Engineers Comments Regarding Surface Water Drainage

Application Reference:	Y/8/26/DOC	Reviewer Reference:	ADC/EXT5/AF
Planning Officer:	Hebe Smith	Date of Review:	24/04/2026
Site Name:	Tyrolean Lodge Main Road Yapton BN18 0EA		
Application Description:	Approval of details reserved by condition under Y/32/23/PL relating to condition 8- Surface Water Drainage.		
Assessment Number:	2

Application Reference: Y/8/26/DOC Site Name: Tyrolean Lodge Main Road Yapton BN18 0EA	Initial Issue Date: 19/03/2026 Issue Date: 24/04/2026 Reviewer Reference: ADC/EXT5/AF
--	--

DRAWING NO: 0007_500
TITLE: DRAINAGE PLAN AND DETAILS

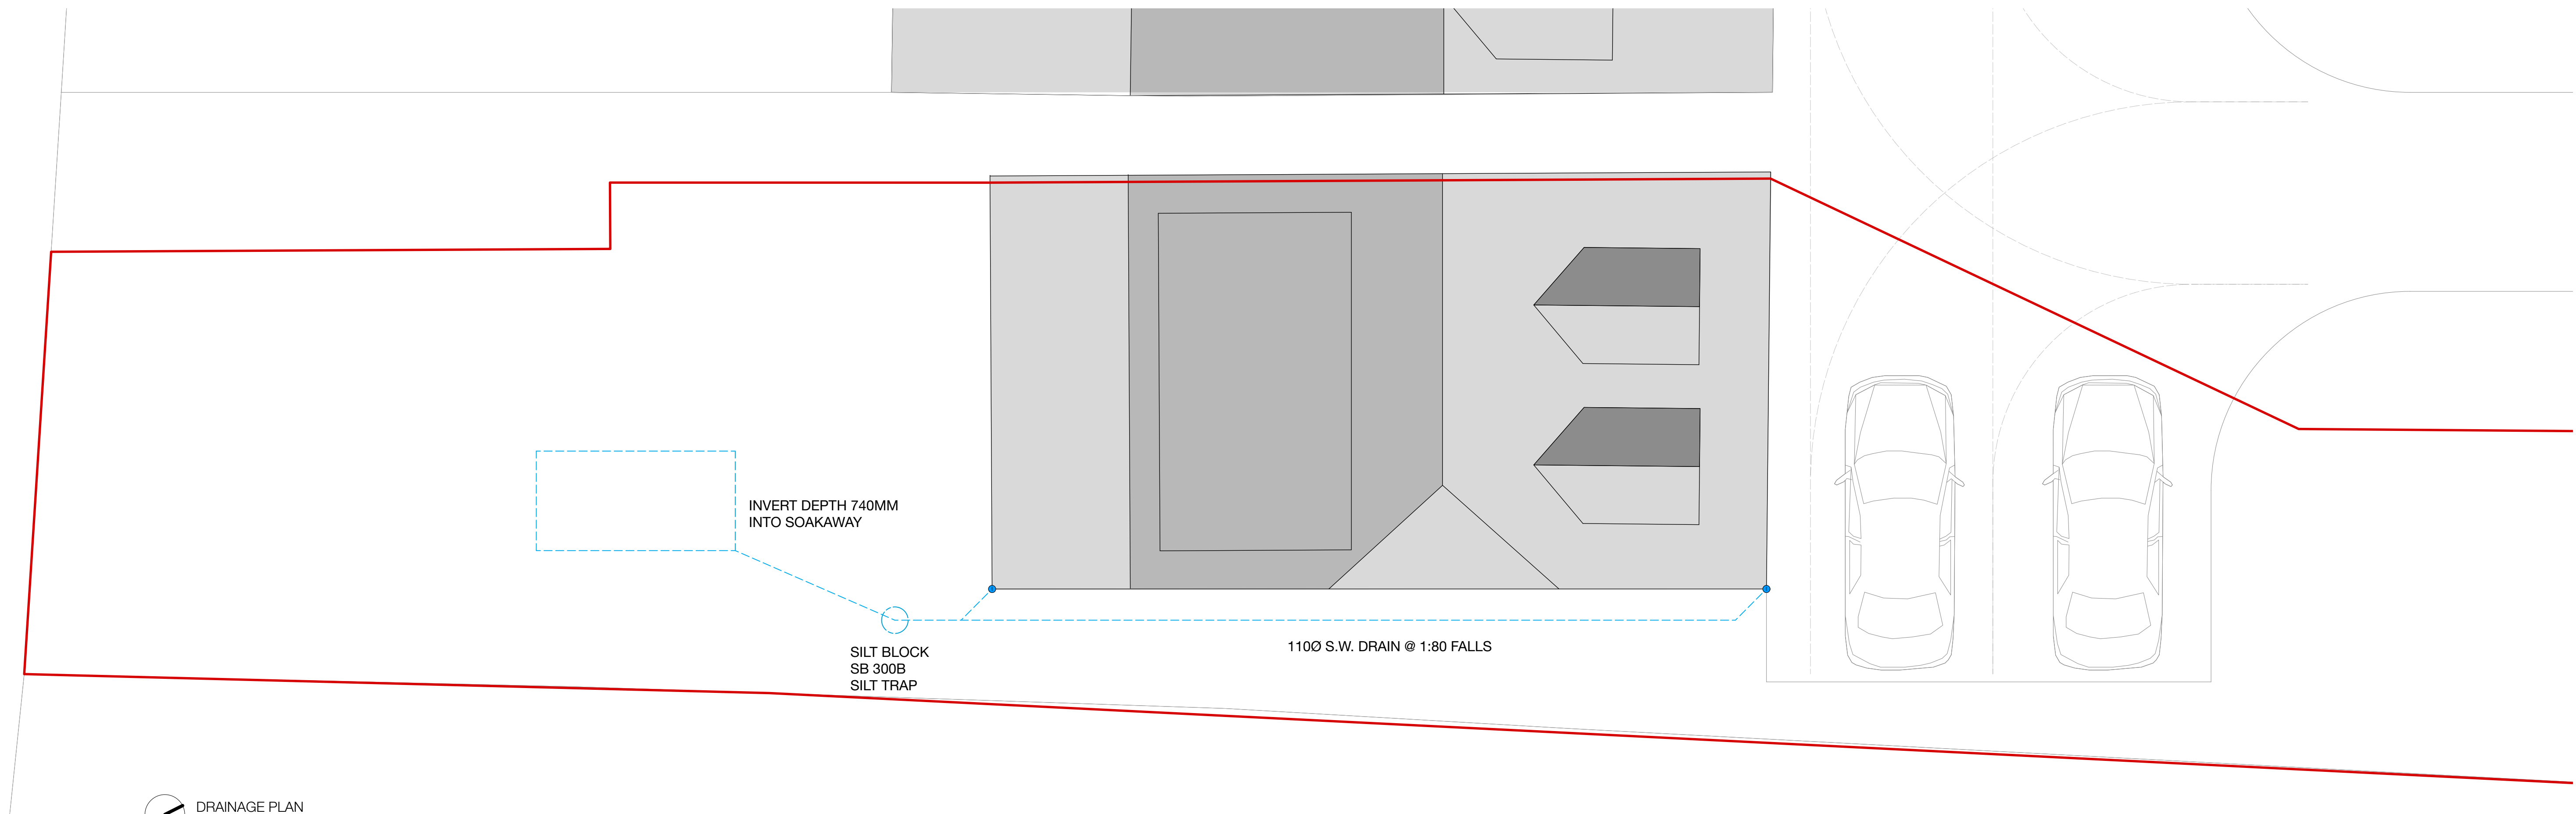
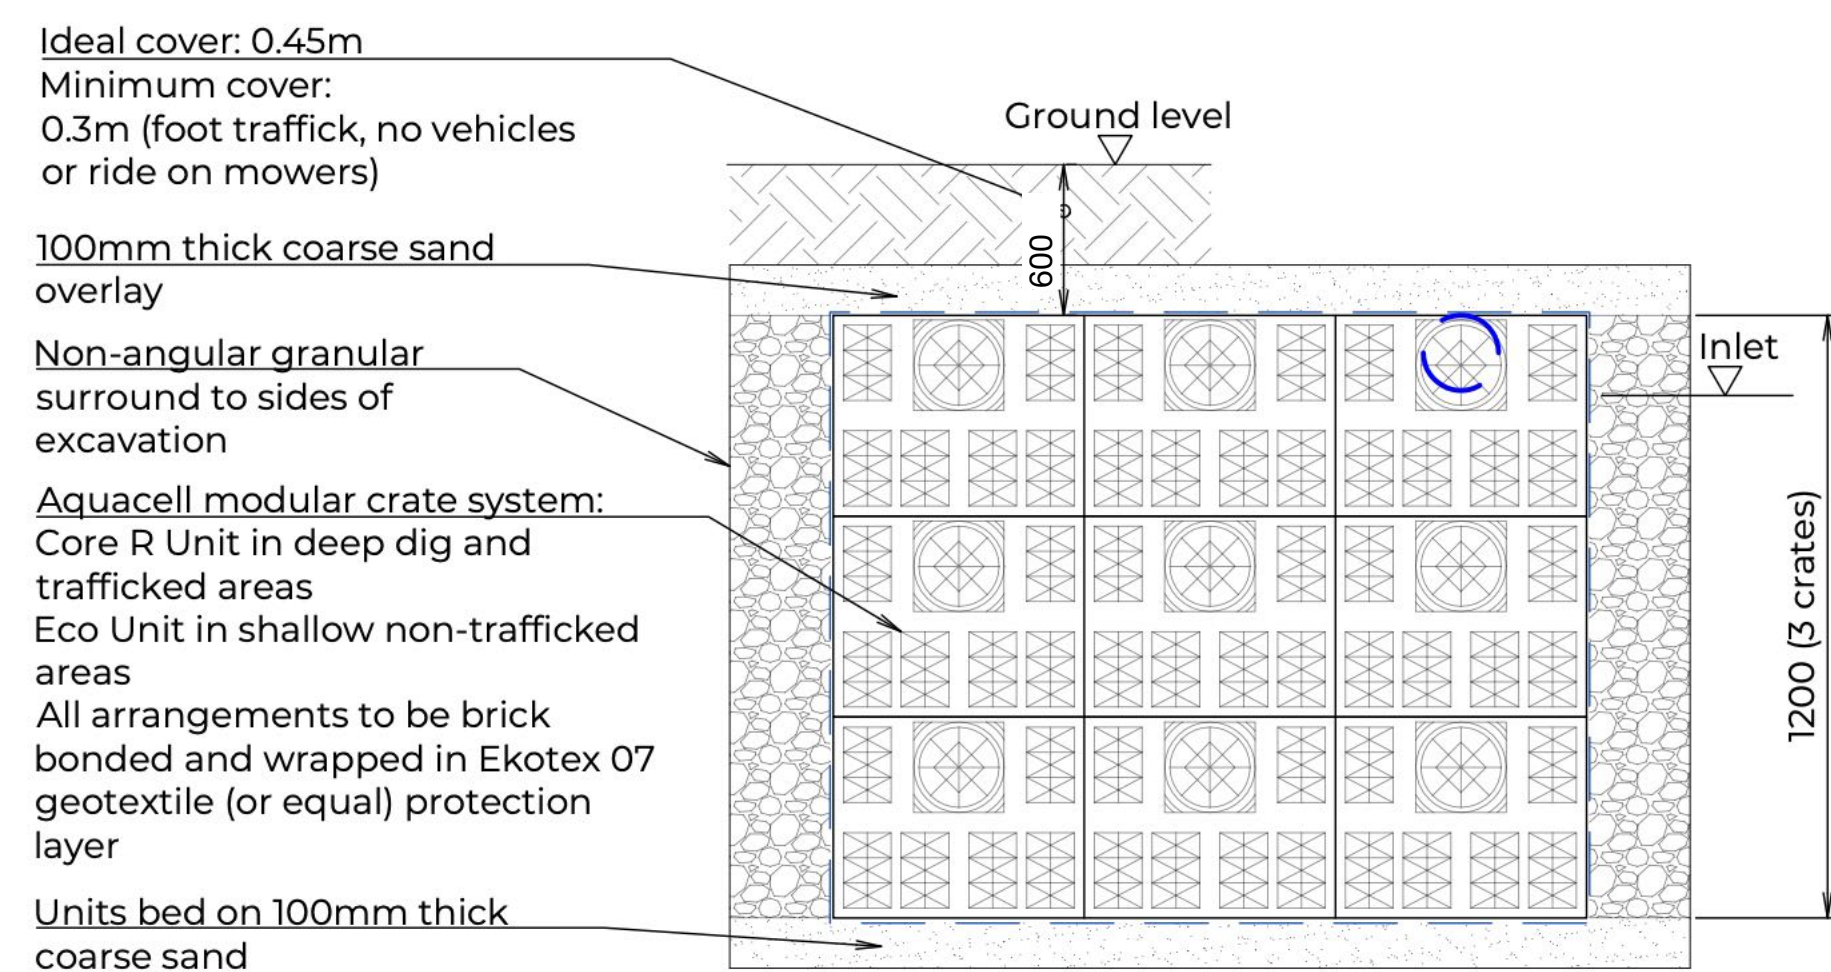
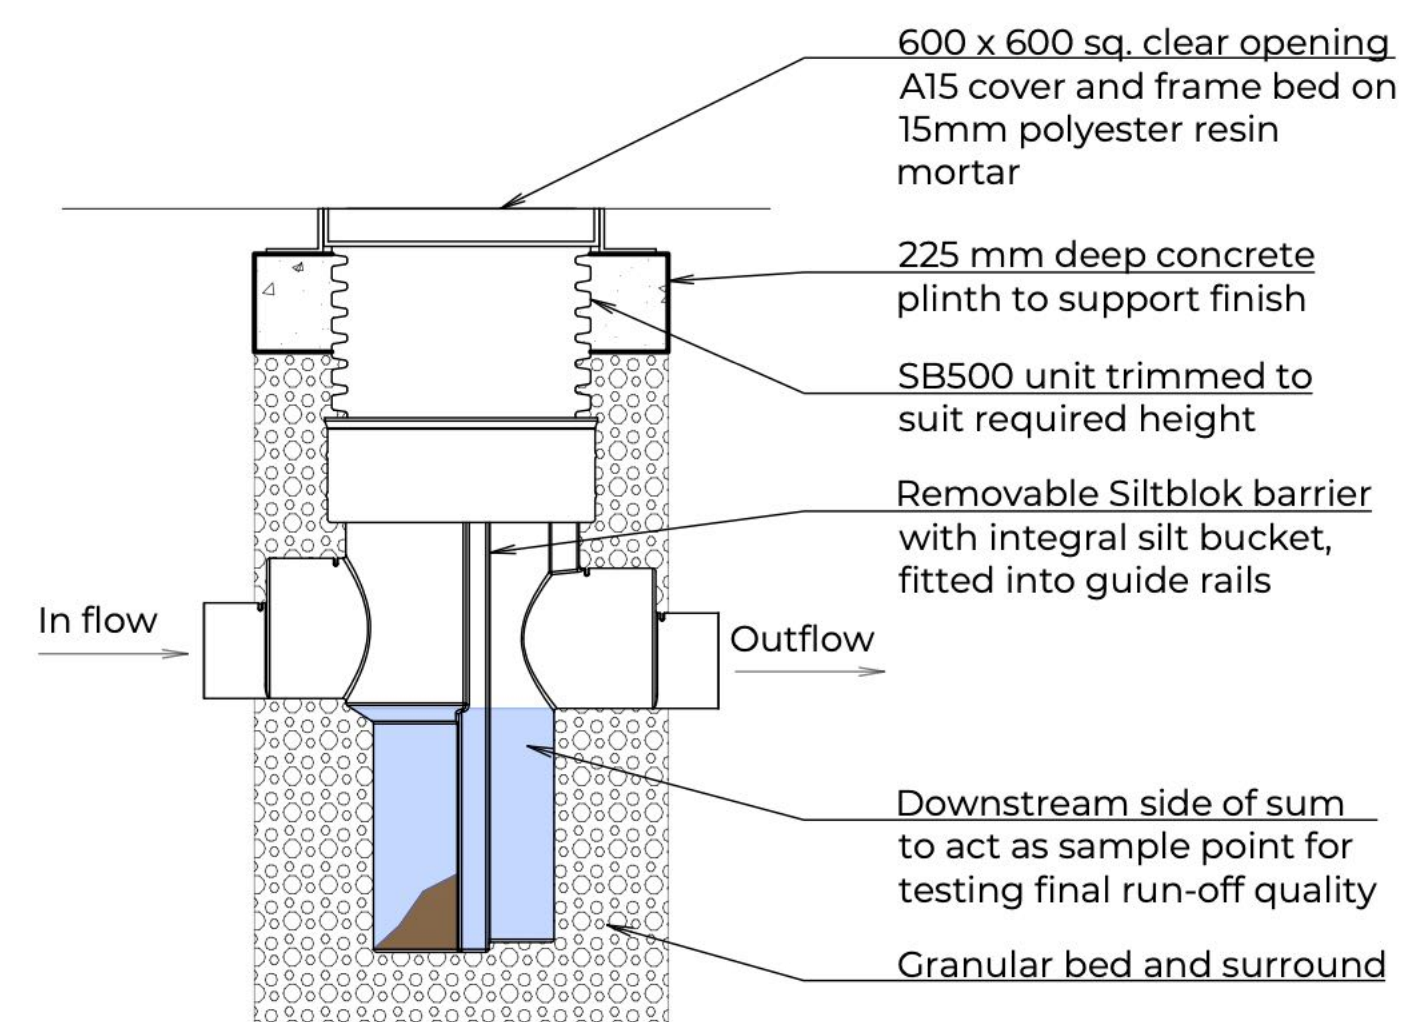
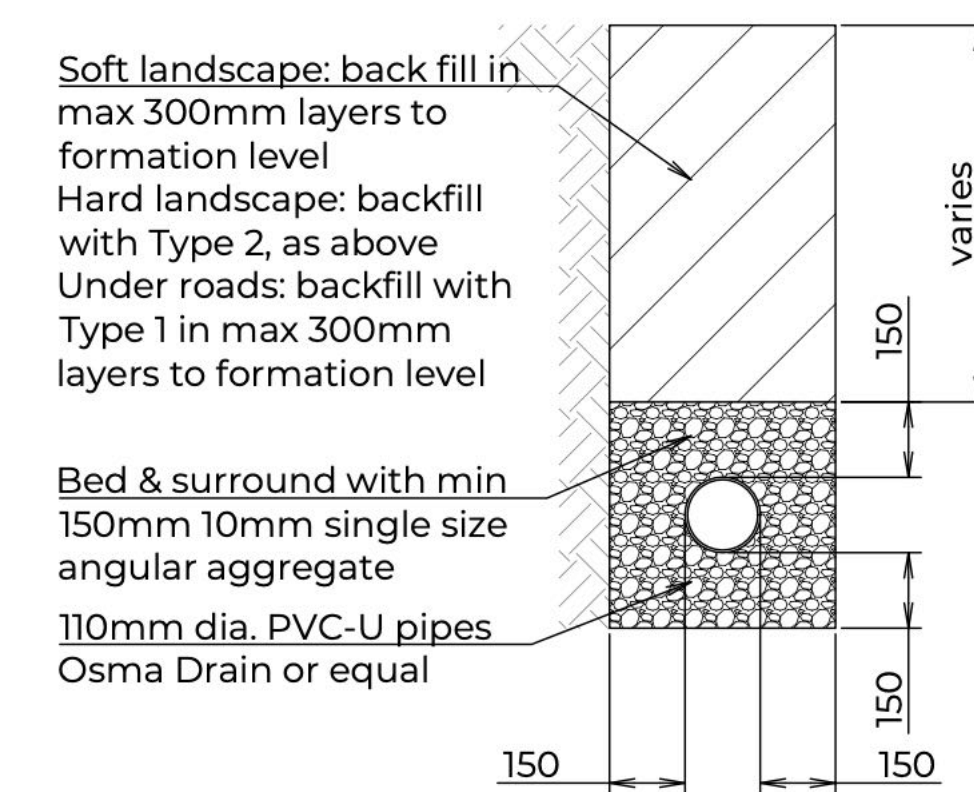
similar to the soakaway design.				
3.	The groundwater monitoring provided appears to show a highest GW level of 3.25m bgl but this is not shown on a soakaway design drawing. A minimum of 1m vertical distance must be maintained above the high winter groundwater level.	Peak GW level appeared at 3.25m below ground level. The base of the soakaway is shown at 1.74m below ground level giving a vertical distance between them of 1.51m	Comment closed

4.	A Drainage Layout Plan and Construction Details should be provided suitable for RIBA Stage 4 Technical Design.	Site plan attached showing surface water drainage layout and construction details.	Comment closed.

5.	No calculations are provided for extreme rainfall. See guidance on Arun DC webpages.	Revised calculations attached which take into account extreme rainfall.	The calculations do not include the design storm which is the 1% AEP plus 45% climate change allowance. This was noted to be required in comments made at planning stage.
